re:	Grading Plan Review
	Proposed Residential Development
	Trails Edge West – Block 140 - Ottawa, Ontario
to:	Richcraft - Ms. Fairouz Wahab – fwahab@richcraft.com
date:	April 29, 2025
file:	PG6406-MEMO.01 Revision 1

Grading Plan Review

Grading Plan - Project No. 160401759 – Drawing No. GP-1 - Revision 2 dated January 6, 2025

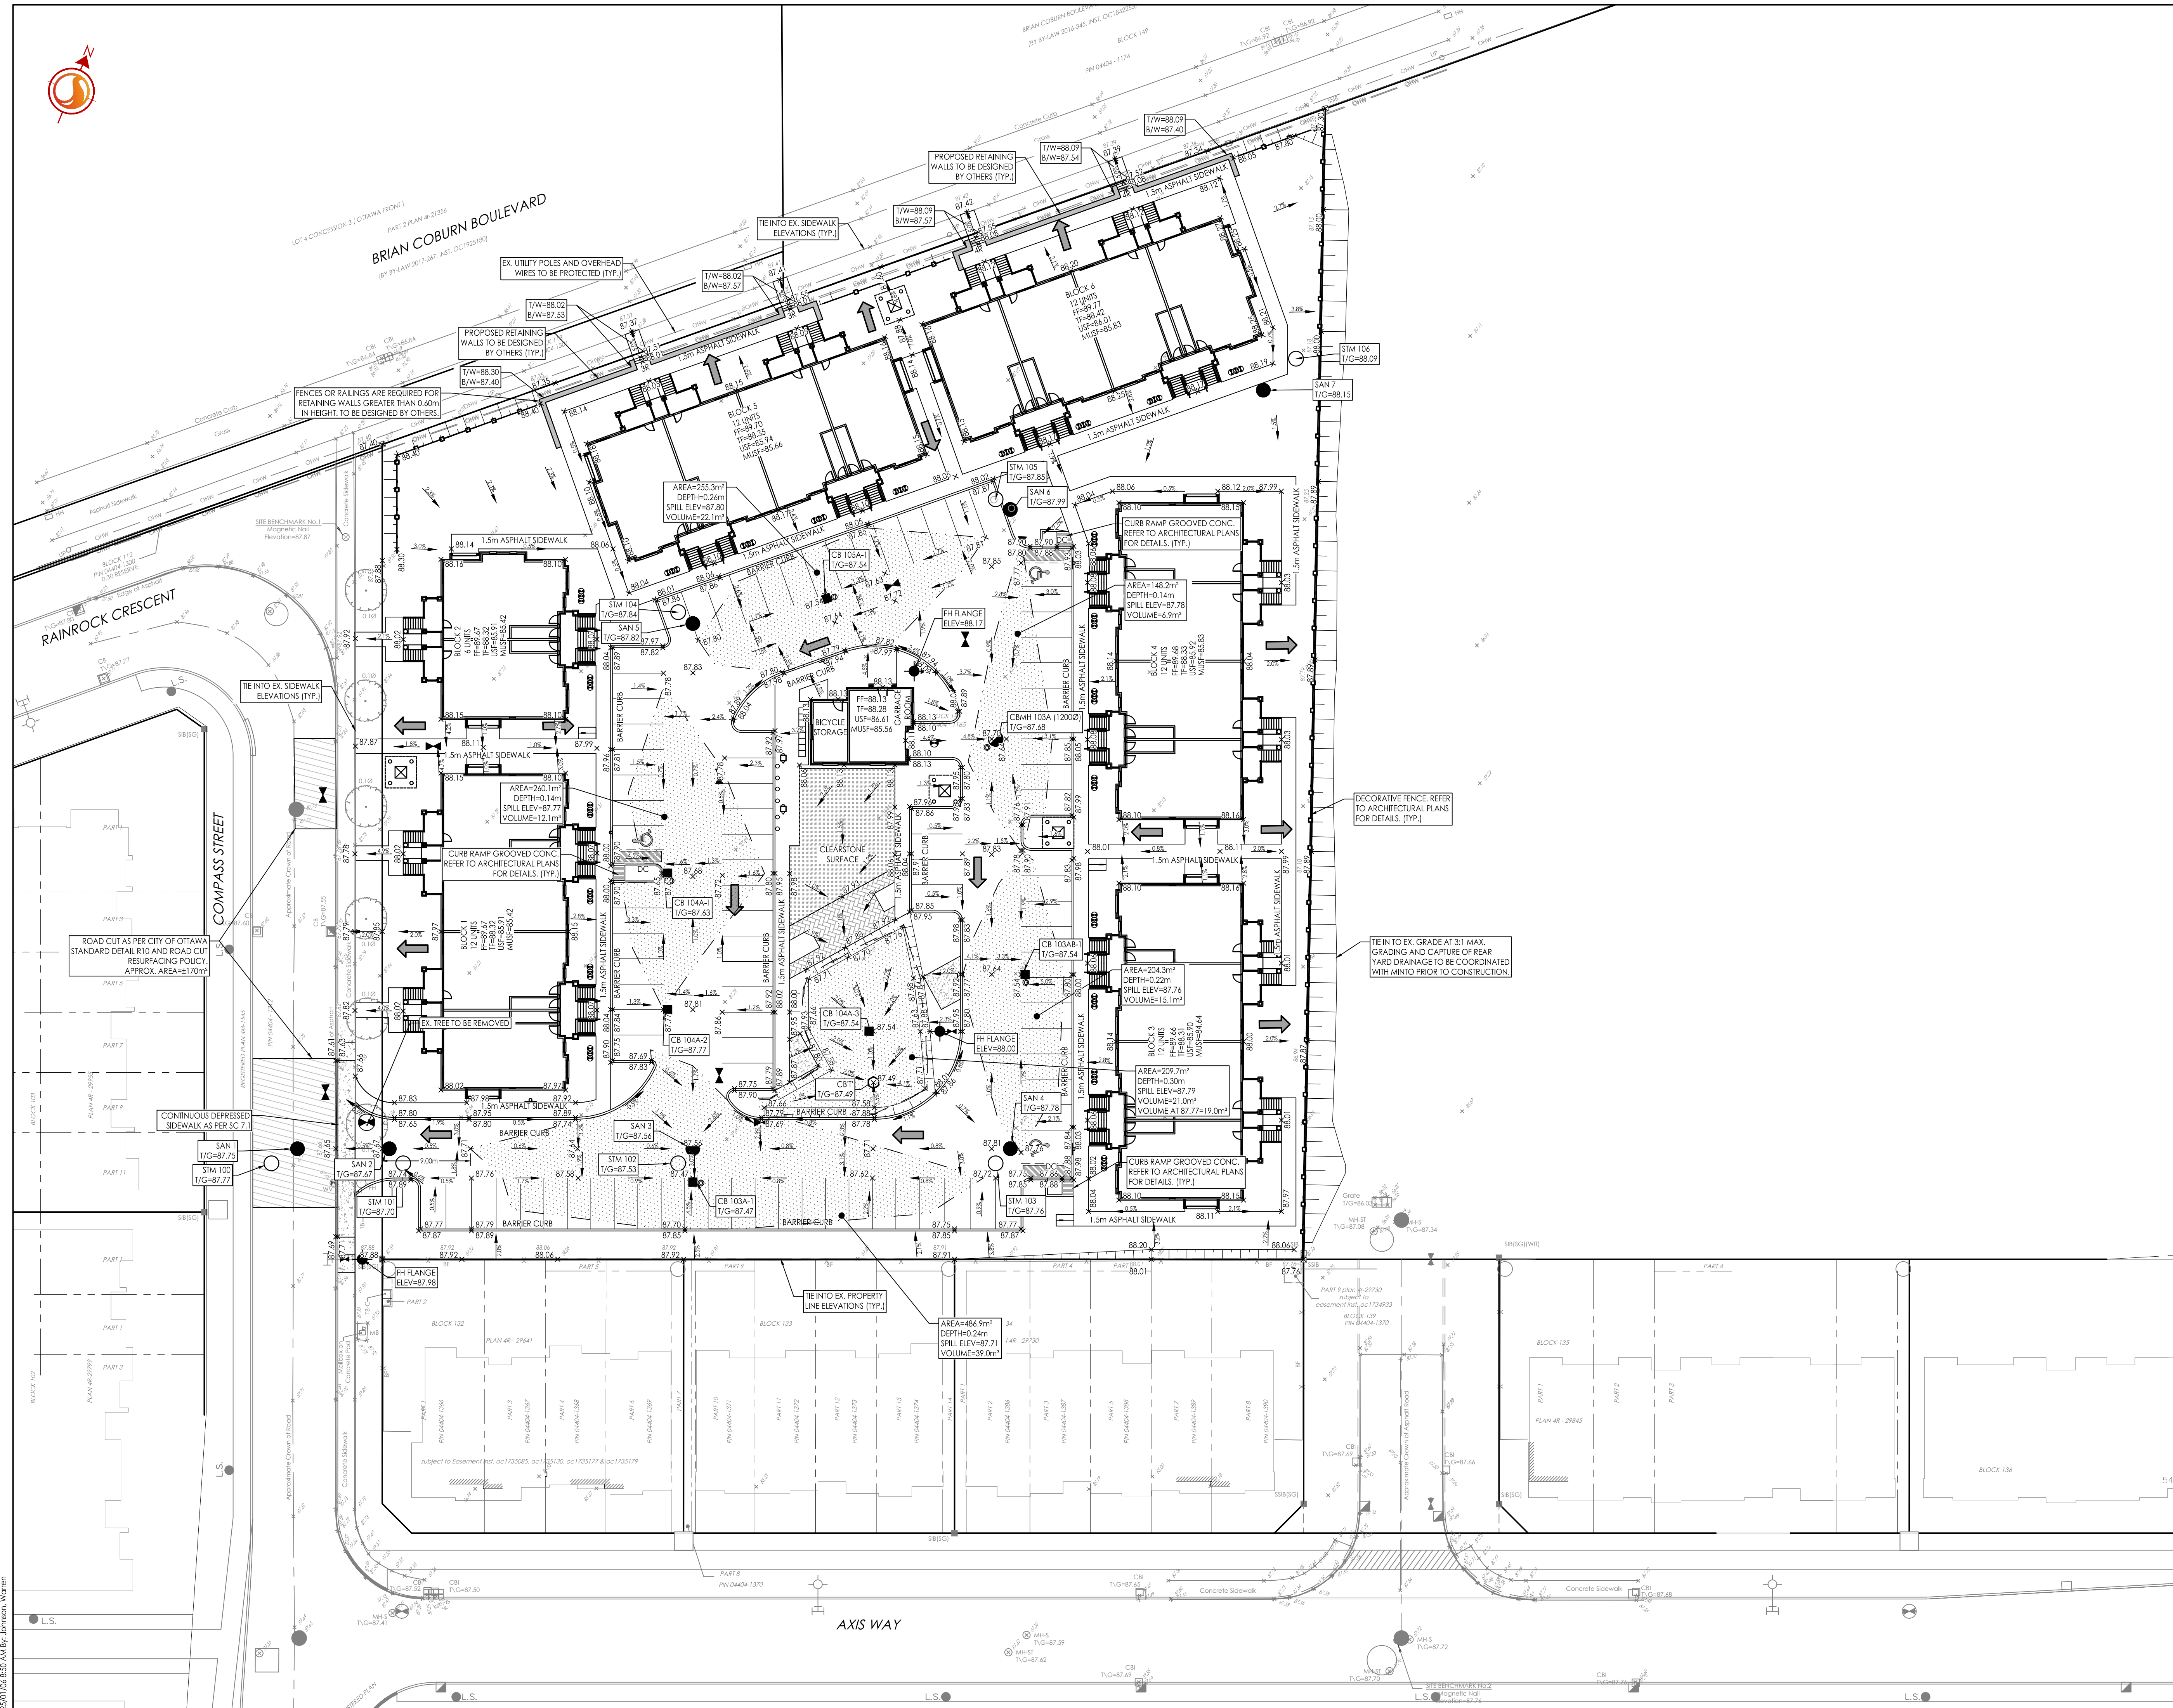
The lot-by-lot grading summary is provided on the attached Table 1. Based on the grading plans provided, the proposed grading does, at a small number of units, marginally exceed the permissible grade raise recommendations provided in the above-referenced Geotechnical Investigation Report. Therefore, lightweight fill (LWF) is recommended below the garage (if applicable) and front porch of the subject units.
